From: Amanda Scholes on behalf of Planning.Responses
Sent: 13 July 2018 09:36
To: Planning Scanning
Subject: FW: Reserved Matters application: A/38/18/RES - Manor Nursery, High Street, Angmering

Comments Relating to Surface Water Drainage

Proposed Surface and Foul Water Drainage Layout

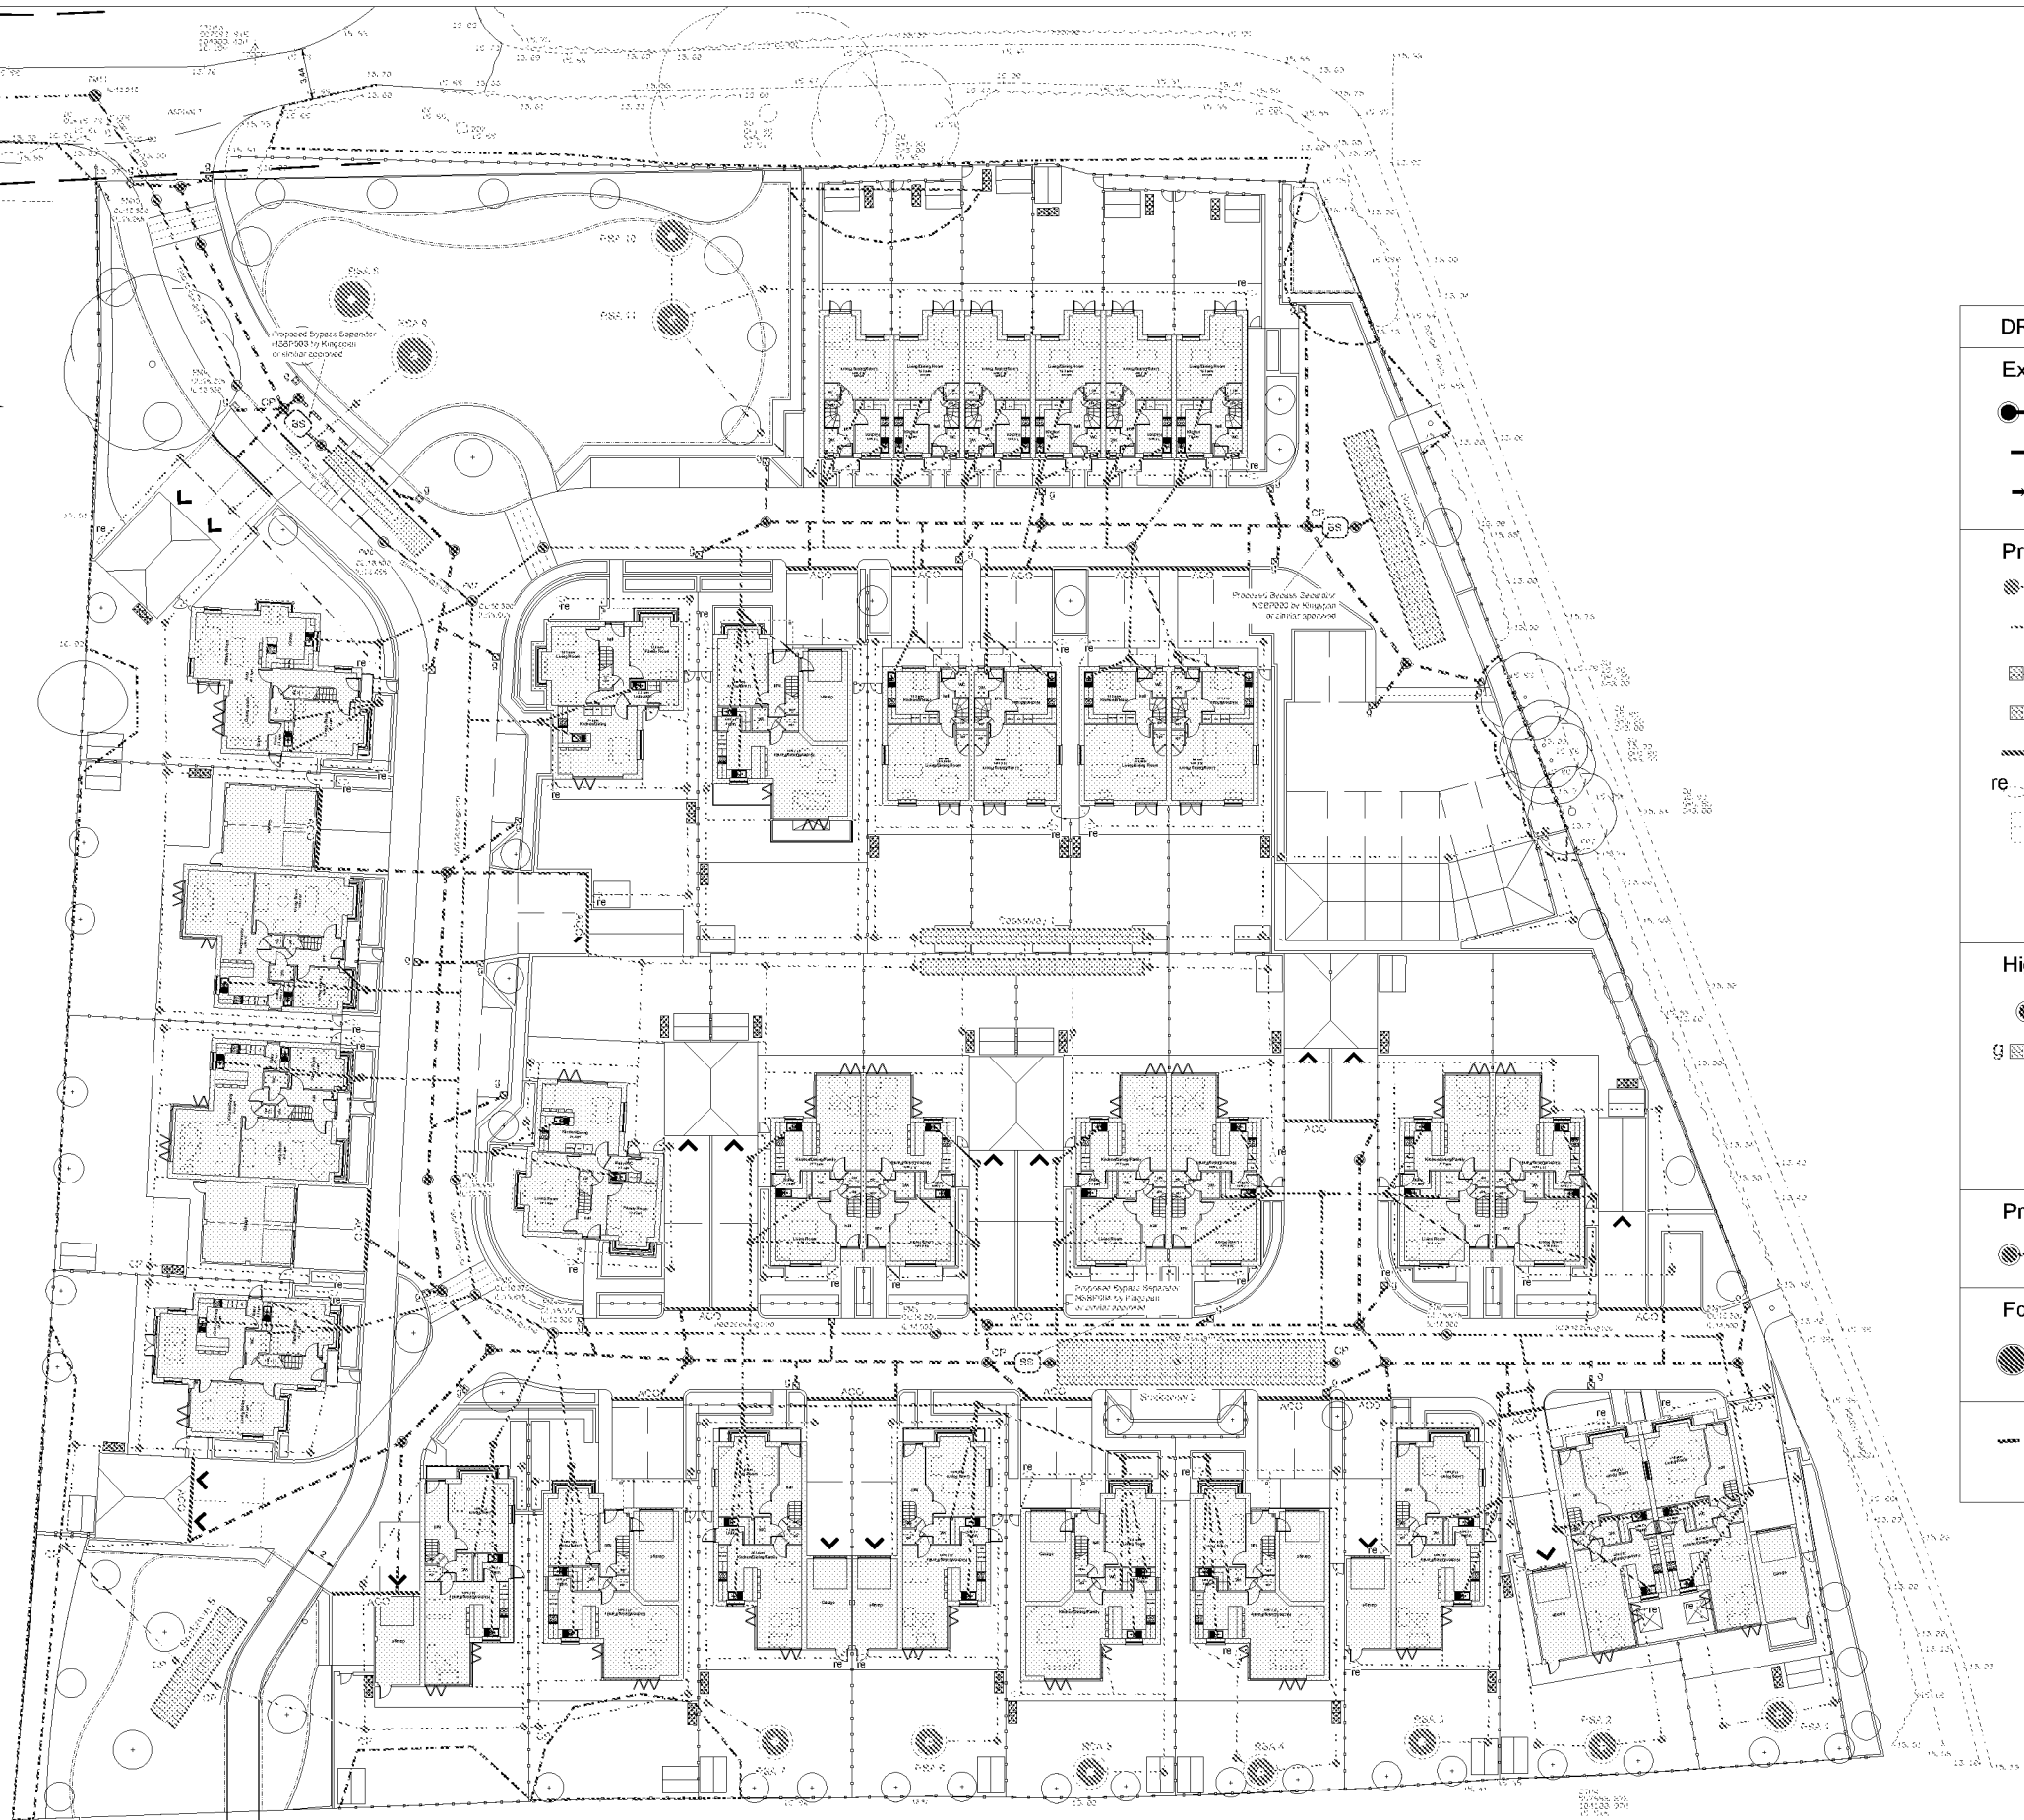
A revised surface water drainage scheme has been provided. Which is a move away from the previously proposed permeable paving. Winter groundwater monitoring and infiltration testing will need to be completed to accompany any DOC application to determine the efficacy of these proposals.
Our comments and conditions regarding A/51/14/OUT still apply.
Regards,
